Part single/part double rear extension incorporating garage and dormers to front elevation

GOOSE CHASE, RIBCHESTER

SUPPORTING STATEMENT

8th August 2012

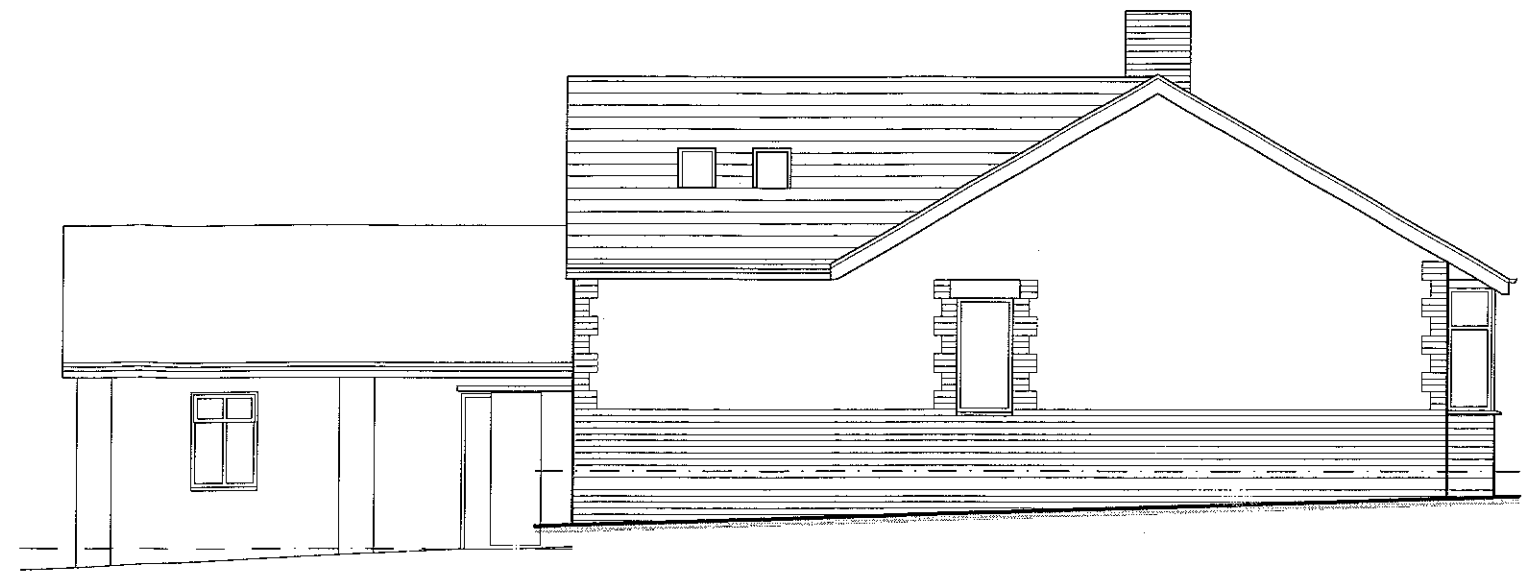
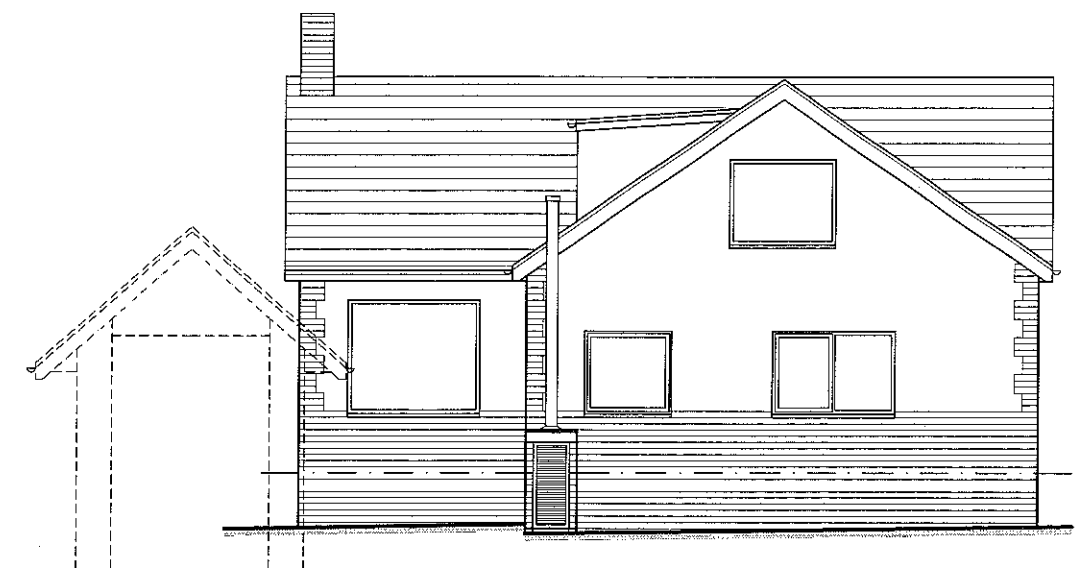
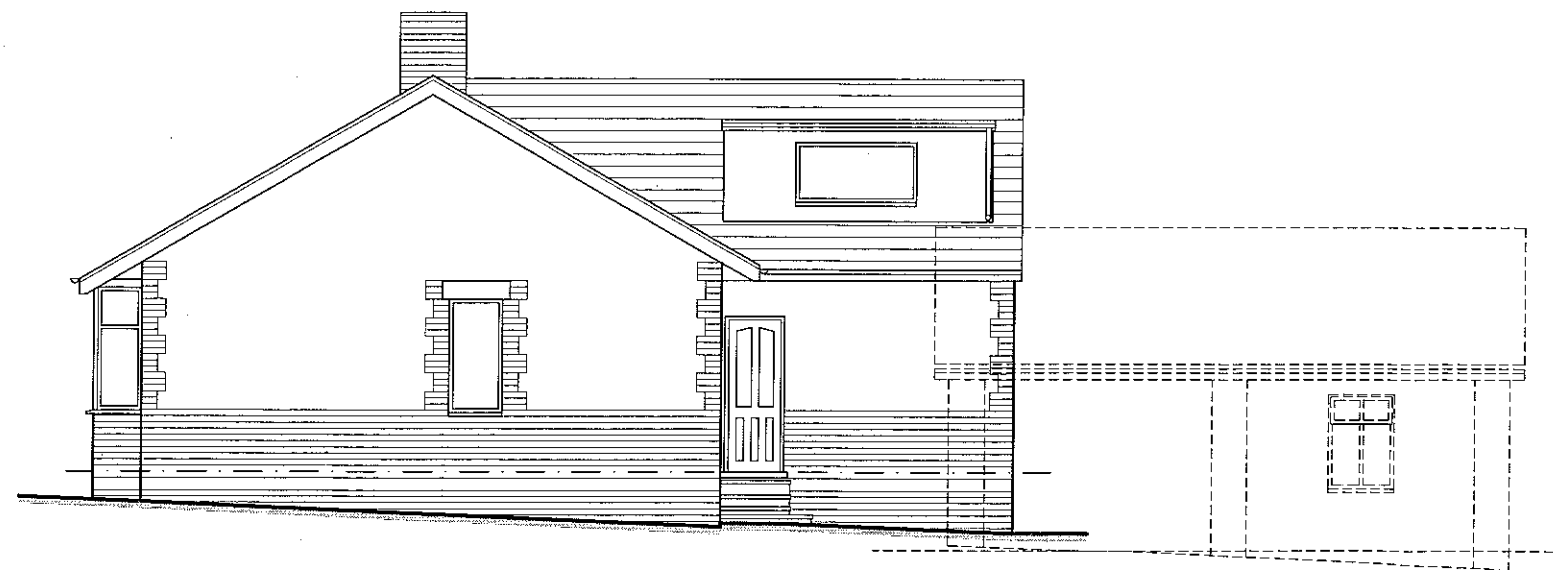
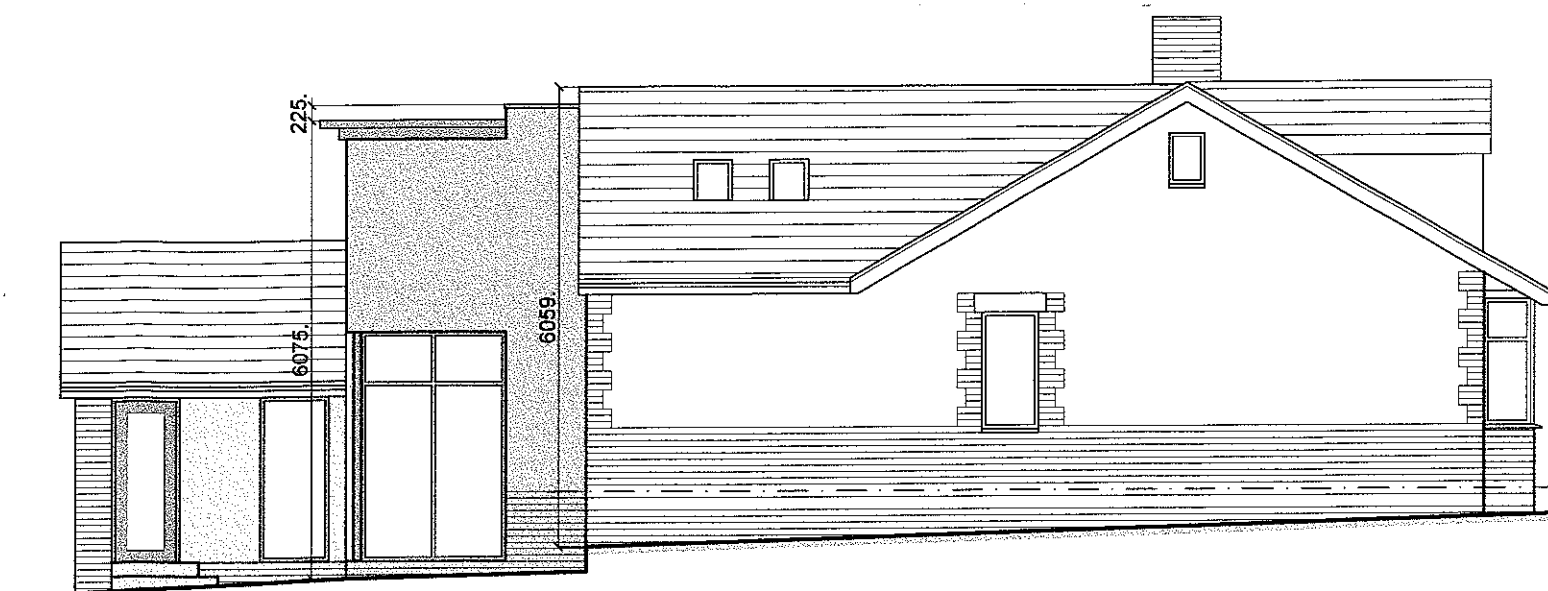
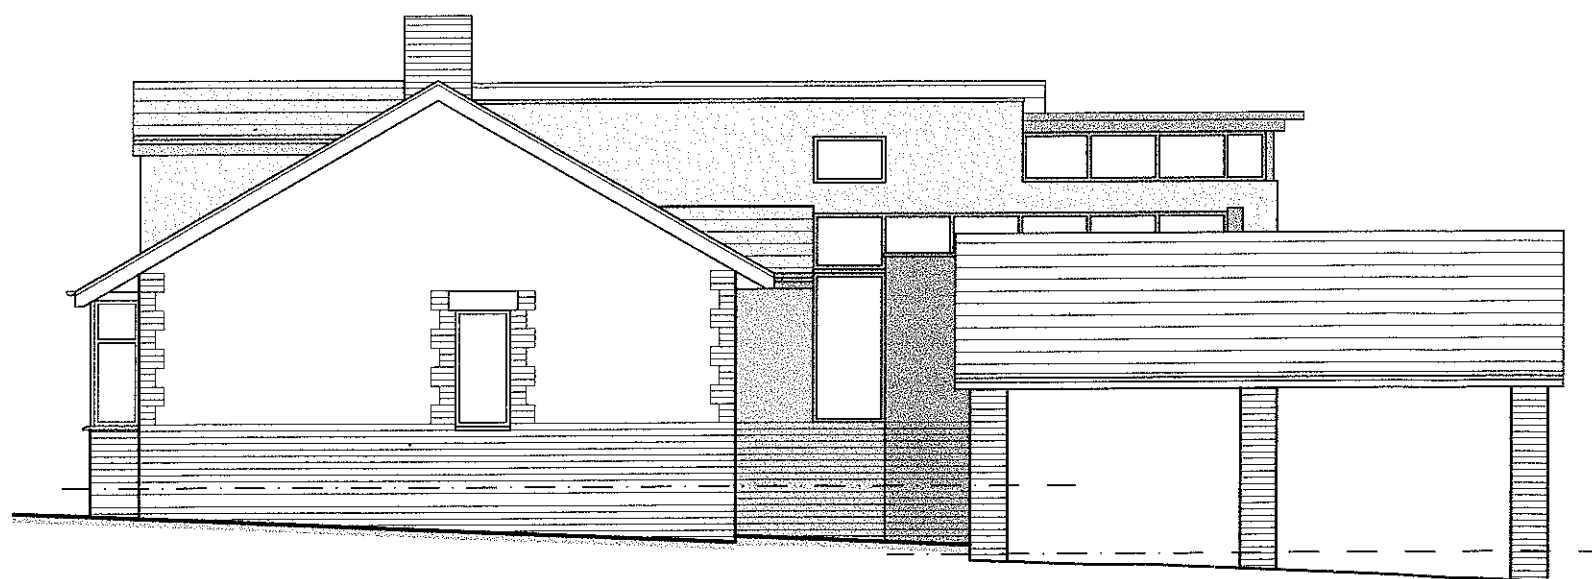
My one major concern is the flat roof at first floor level. As stated above, general advice in the Supplementary Planning Guidance suggests that flat roofs should be avoided. I have concerns about the resulting linear bulk of the extension at the south- eastern elevation, which will be visible from Preston Road. The flat roof gives the extension an unsympathetic feel, introducing dominant expanses of walls particularly to the north western elevation. As such, I feel the scheme as presented would be unlikely to receive planning permission. Although onsite we discussed the challenges with the existing roof pitches and slopes, which necessitated this design response, it is my view that a scheme more sympathetic and subservient to the exiting roof scape would be more likely to receive planning permission.

Having considered the comments of Mr Fort it was agreed that the massing of the Western elevation due to the flat roof was *'introducing a dominant expanse of wall'* and that there was obviously a need to review this. Image one shows the rear of the property as existing and although alternative solutions to the flat roof have been considered it was felt that these would be detrimental to the scheme as a whole and even the best alternative resulted in a strange double gable with a higher ridge and an awkward valley detail.

In order to address the massing using the flat roof it is proposed to break up the wall by removing a section of the parapet, expose the edge detail and provide a layer of glazing below that wraps around the corner. The before and after images, reflect how this reduces the massing and creates a lighter more attractive detail to the corner. The line of the parapet is consistent with the original building line and is therefore a reflection of the existing massing created by the flat roof dormer (image 2 and 3). We believe that having modelled the proposal that although the flat roof doesn't conform to normal local policy it reflects the aspirations of the NPPF and would be grateful that when the scheme is considered the borough would *not stifle innovation, originality or initiative through unsubstantiated requirements to conform to certain development forms or styles.*

The use of a flat roof is generally viewed as being unacceptable to most people due to their preconceptions of constants leaks and unsightly detailing (image 4). Current flat roofing systems however offer a solution that is not only guaranteed in terms of performance but are also crisp in their aesthetic when detailed correctly. Though it is understood that the boroughs current guideline is to avoid flat roofs we believe in this instance the proposed detailing of the flat roof justifies its approval.

Image 5 shows the type of verge detail that is proposed using a Dales fabricated aluminium system and the intention for the scheme is to utilise innovative construction methods such as a timber frame and green roofs.
